Kidz Academy Preschool & The Human Bean  
Kidz Academy Preschool Ladera Real Estate LLC / Tres Lobos, LLC.  
General Permit SWPPP Inspection

7700 SAGE RD SW  
ALBUQUERQUE, NM 87121

Inspection Date and Time  
Mar 18, 2021, 8:00:23 AM

TEMPORARY EROSION AND SEDIMENT CONTROL PLAN

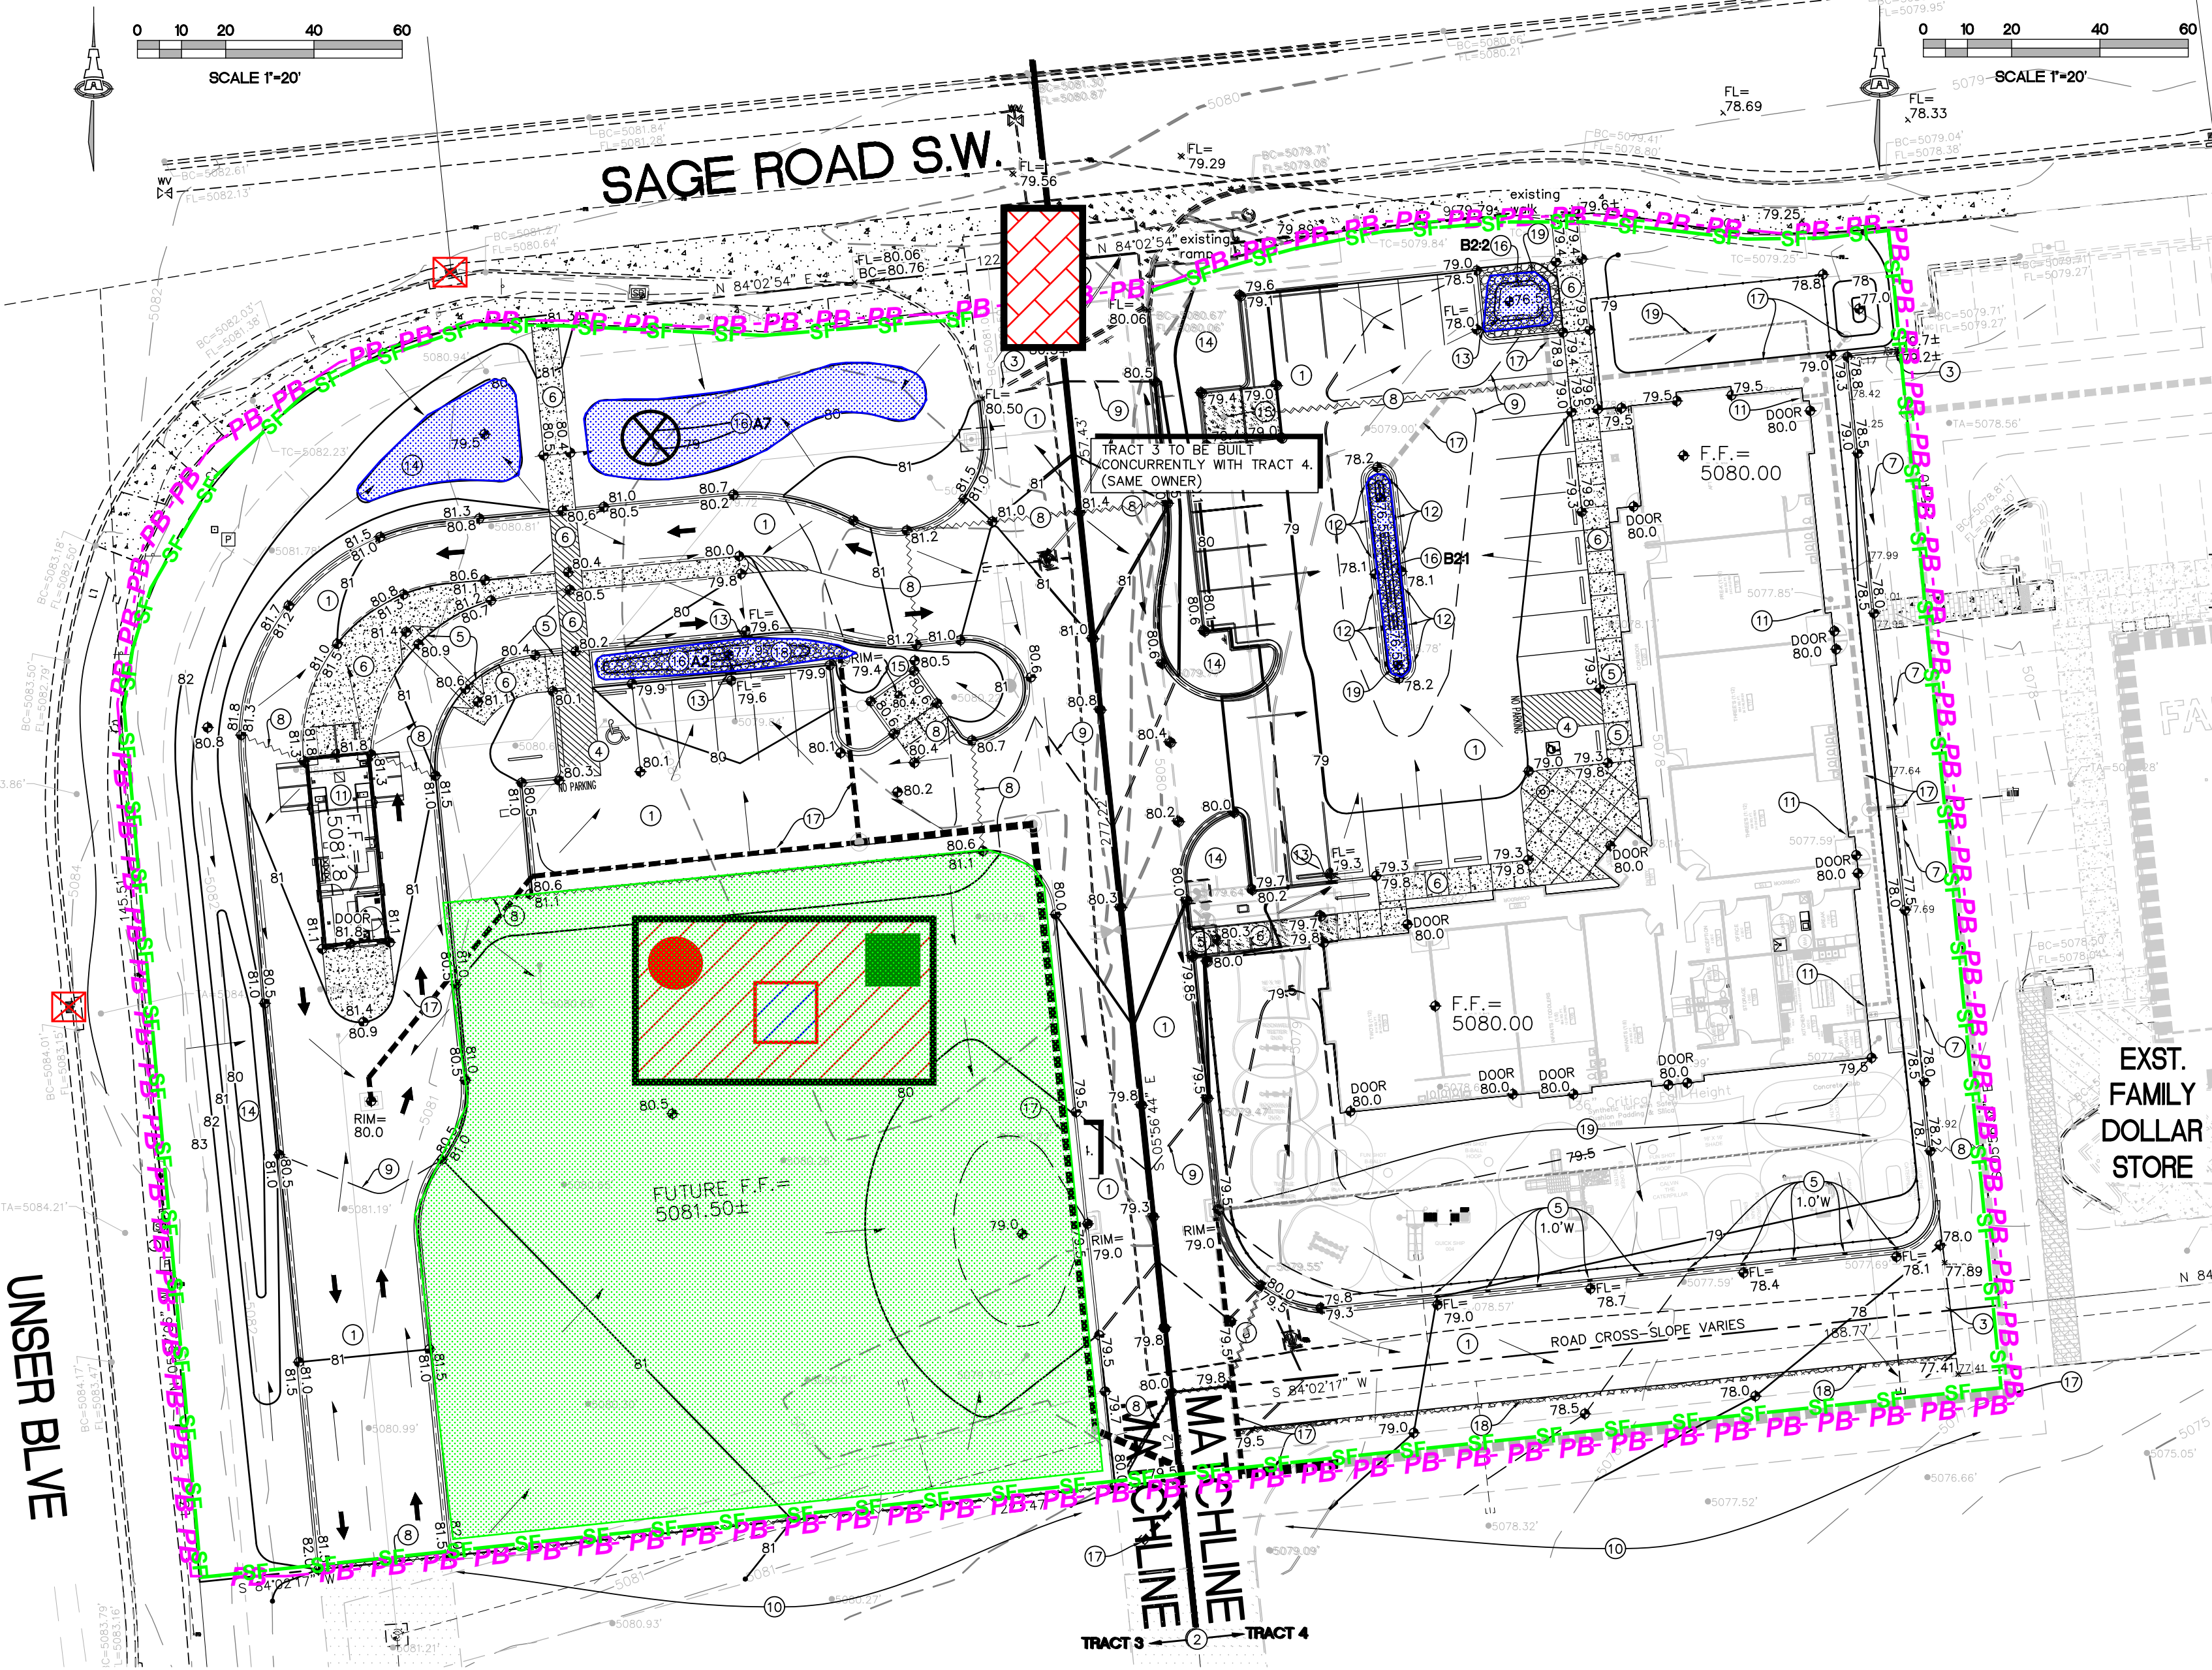
N/A at the time of inspection. No active work, silt fence in in the SE corner has been removed for vehicle access. Repair silt fence, install wattles or similar BMP.

No active work or equipment on site. Silt fence in in the SE corner has been removed for vehicle access. Repair silt fence, install wattles or similar BMP.
